Single storey front/side/rear extension, porch to front, dormer to side to create additional habitable roofspace and landscaping to front to create 2 new car parking spaces
17 Stewards Rise Arundel

Thank you for your internet comments made on 29th July 2019 which has been recorded as **'an objection'** with the comments as follows:

17SRPRELE2018-R02
17 Stewards Rise - Arundel
Proposed Elevations
Scale 1:100 @ A3 (2018)

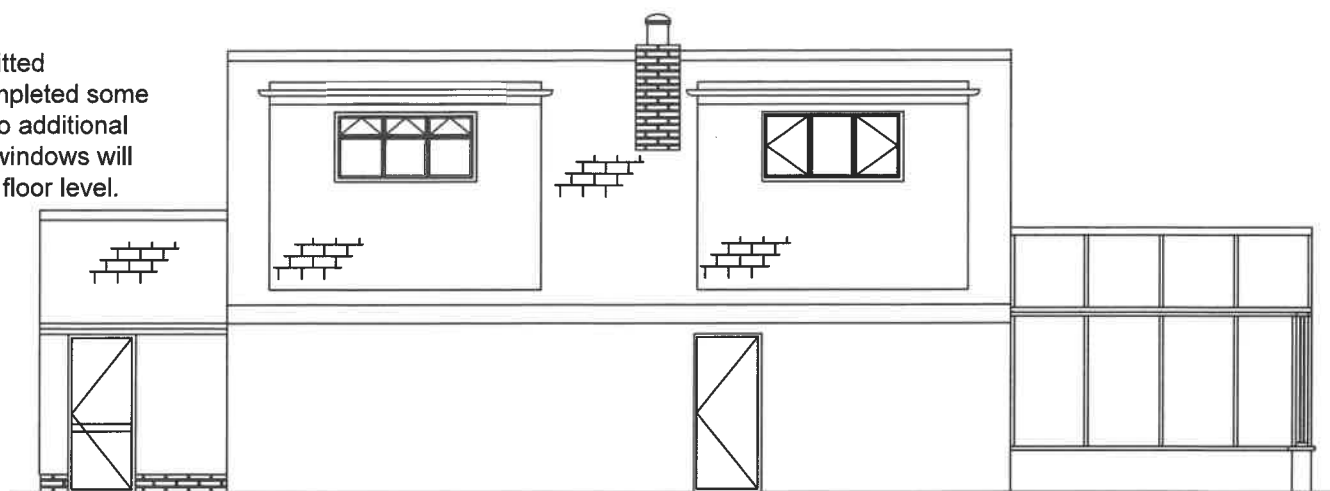
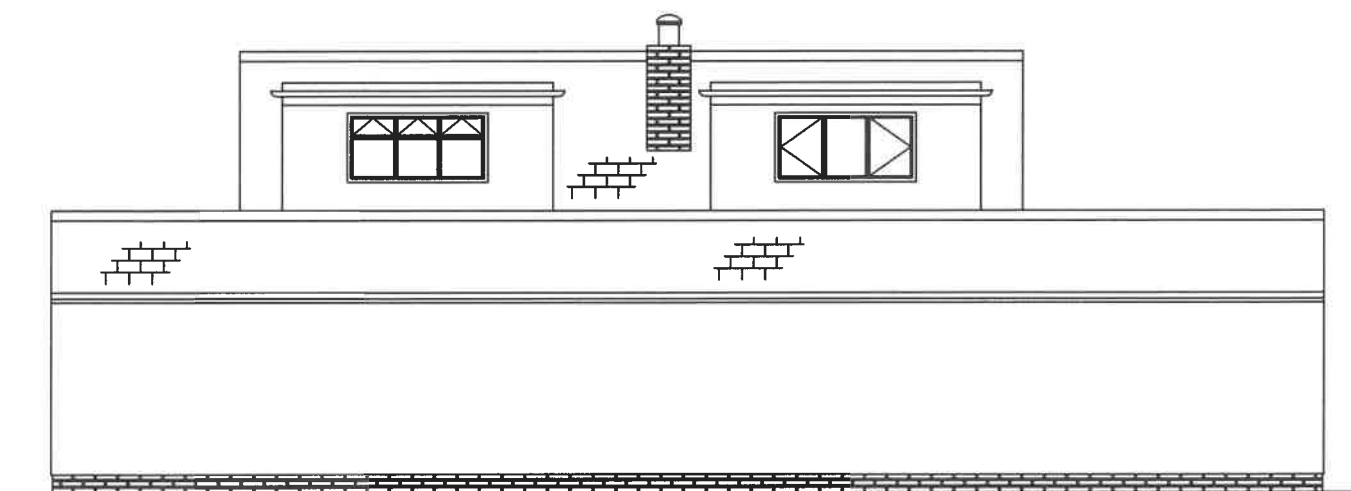
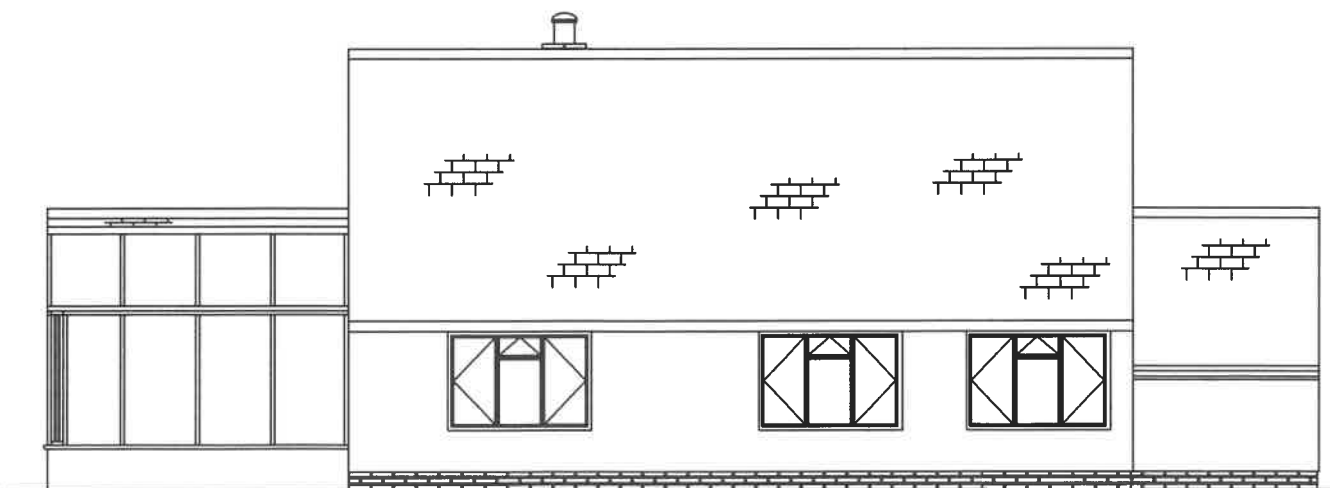
The Committee objected to the proposal on the grounds that the extensions would result in a dwelling of a size uncharacteristic of the more discreet buildings along the road and introduce a large and bulky "box" dormer that would be intrusive and harmful to the more prevailing simple roof forms found hereabouts. The development would also result in the loss of an open area of front garden to additional car parking which together with the existing parking provision would dominate the street scene. Overall, the scheme would result in an unsympathetic form of development that would harm the character and appearance of the area.
